From: Henry Burnett <hburnett@thehills.nsw.gov.au>
Sent: Wednesday, 28 March 2018 11:47 AM
To: Ellen Robertshaw
Subject: RE: Council Submission Kellyville Stage 3

Here is the email trail re: waste management for Stage 3 of the Gracewood development.

From: Leonardo Russi [<mailto:leo@leighdesign.com.au>]
Sent: Friday, 23 March 2018 3:21 PM
To: Paul Zirilli
Subject: Gracewood Village Stg 3 - 8 Free Settlers Dr Kellyville

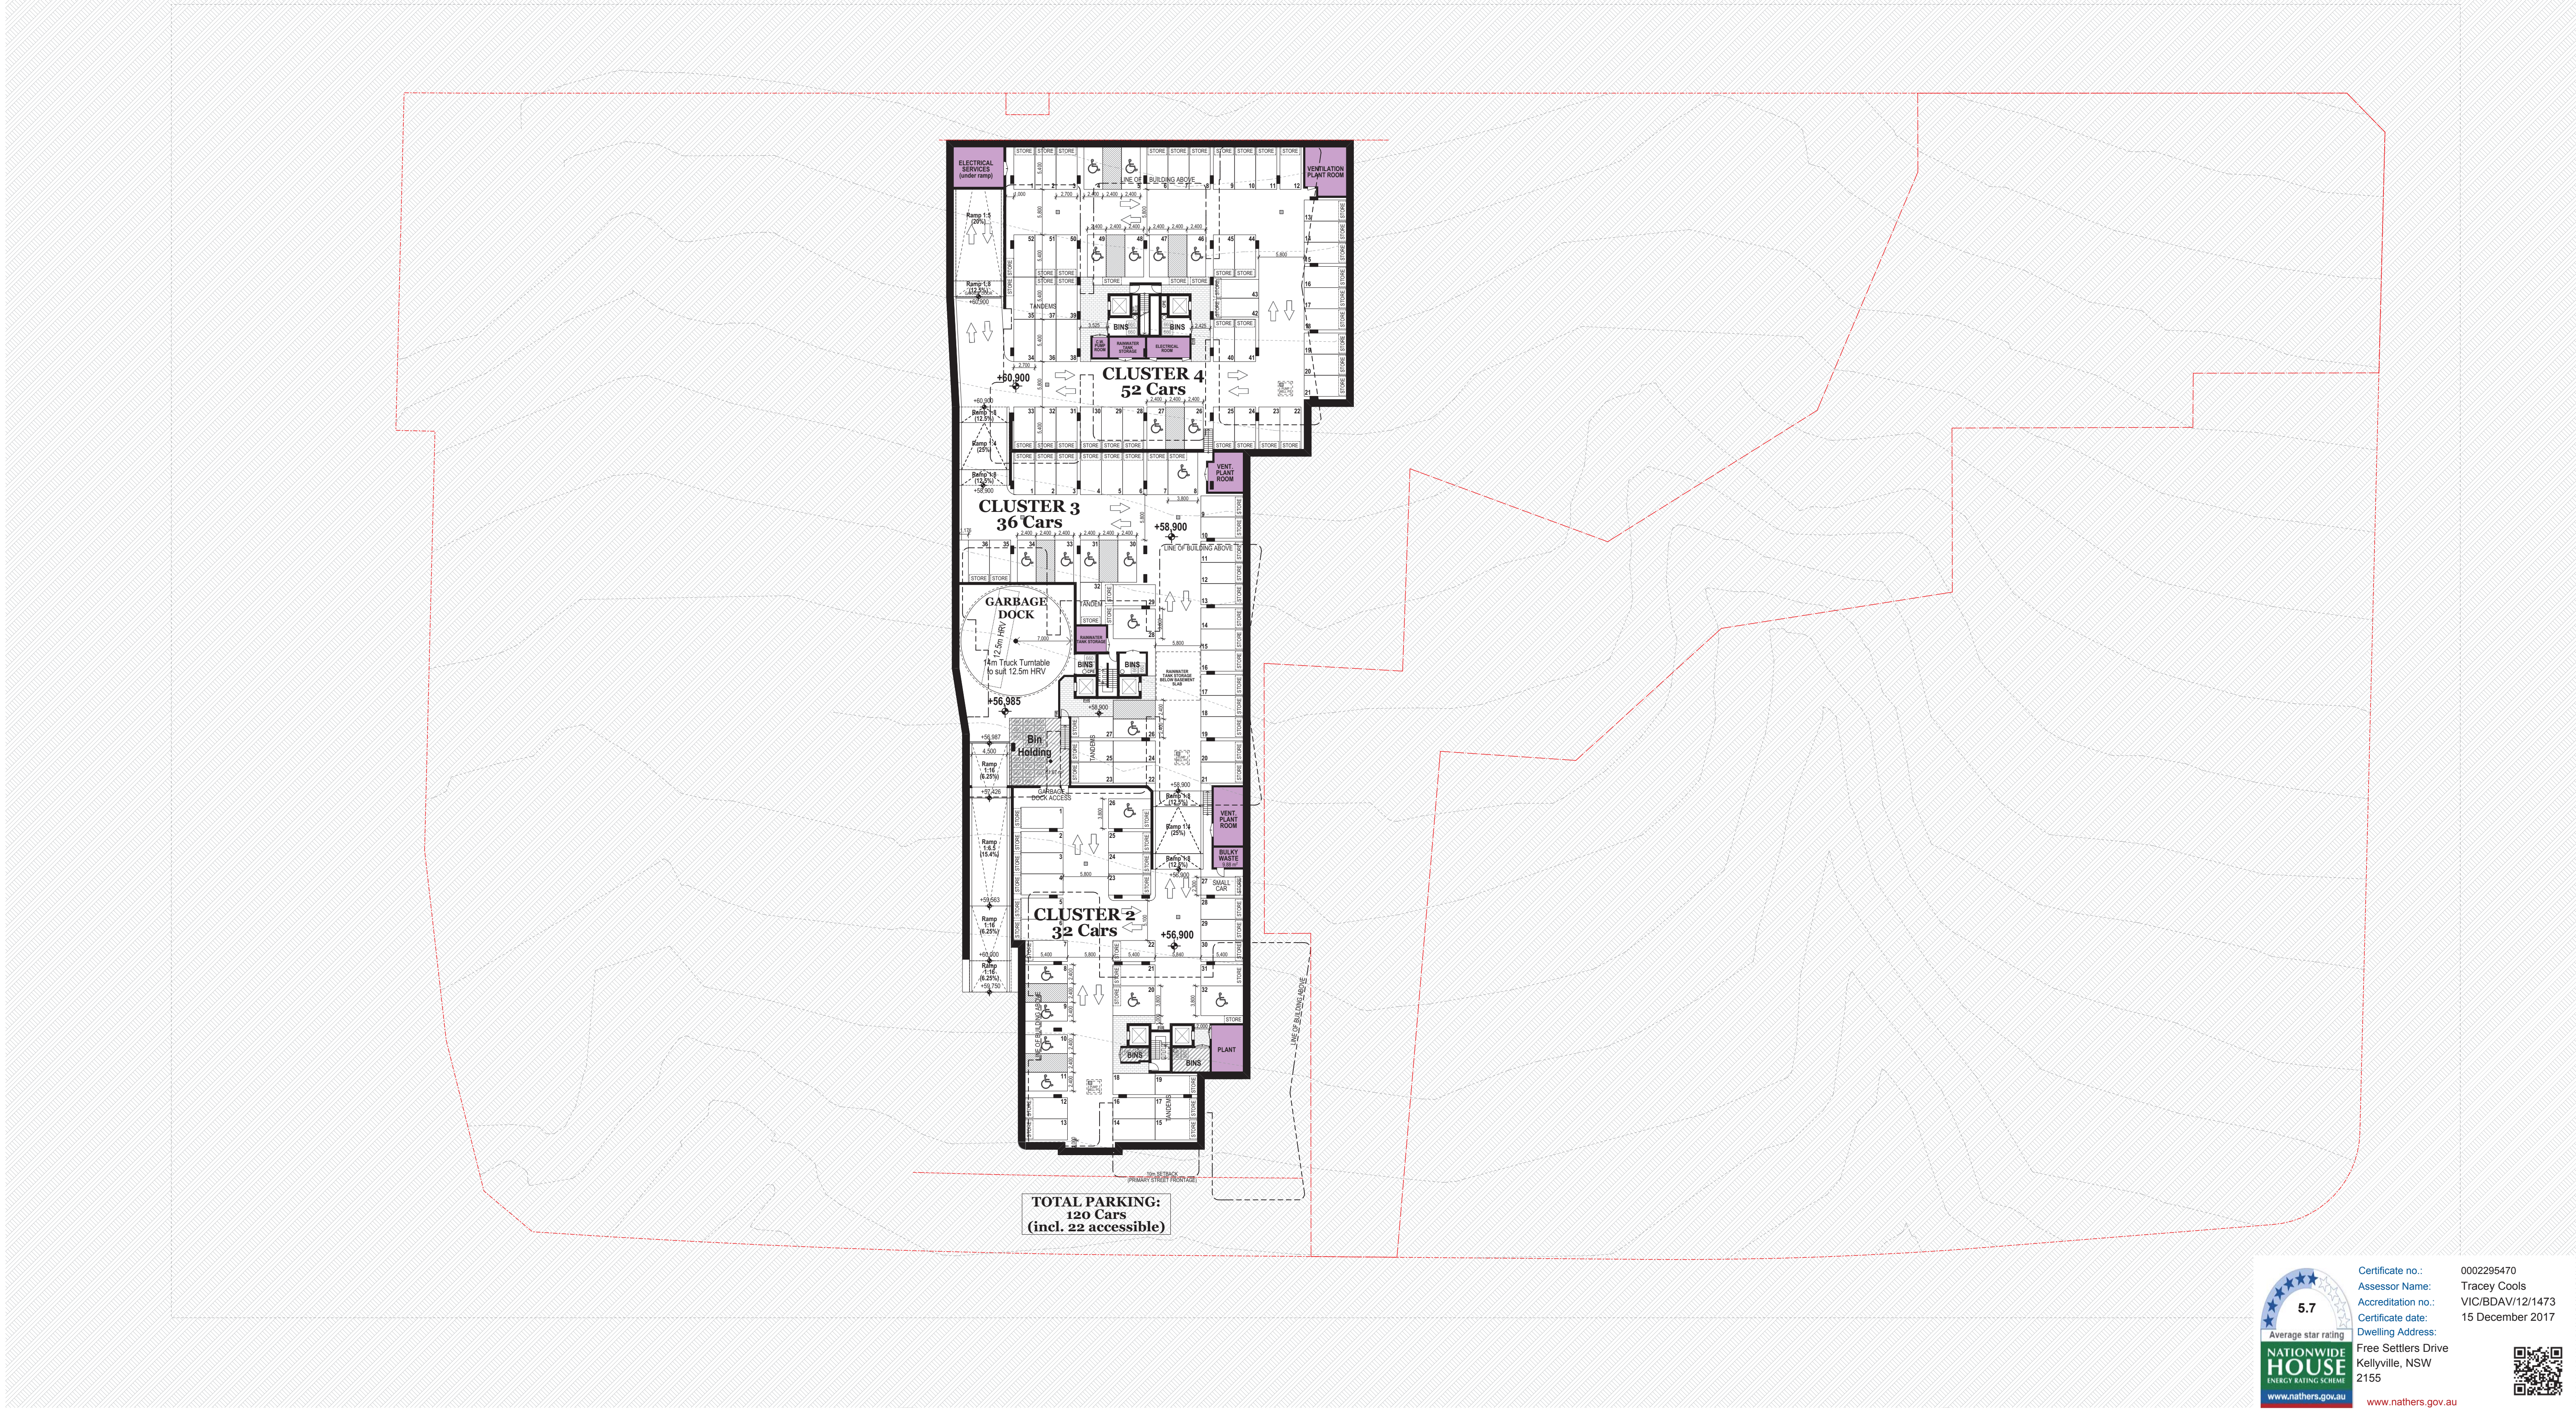
You may remember our brief discussions last year regarding the waste arrangements for the above proposal (see current WMP attached). In the recently-issued Council submission (also attached), there is a suggestion from Council's Resource Recovery Department to delete the proposed refuse truck turntable. The comment does not seem too prescriptive and, in fact, this suggested deletion of the turntable would pose significant issues from the design and planning points of view, as the head clearance required for the operation of the specified waste vehicle would create the need for a large turn-around area in the absence of the turntable. This in turn would leave the development with three basic potential strategies:

Council has suggested in their attached submission that we delete the turntable in the basement.

This is not ideal as it would require turning space for a large truck inside the basement, we had previously explored this option and considered it not feasible as we either needed to lower the basement level for significant extra cost, or raise the building higher resulting in max building height non-compliance.

The email is correct. If alternatives have been appropriately explored and the turntable is the best planning outcome then no objection would be raised. There is not a prohibition on turntables in the context of this application and its history, just a preference for utilising vehicle manoeuvring to achieve forward entry/exit.

Resource Recovery Team wouldn't have any objection to retaining the proposed turntable if it is the most practicable solution.
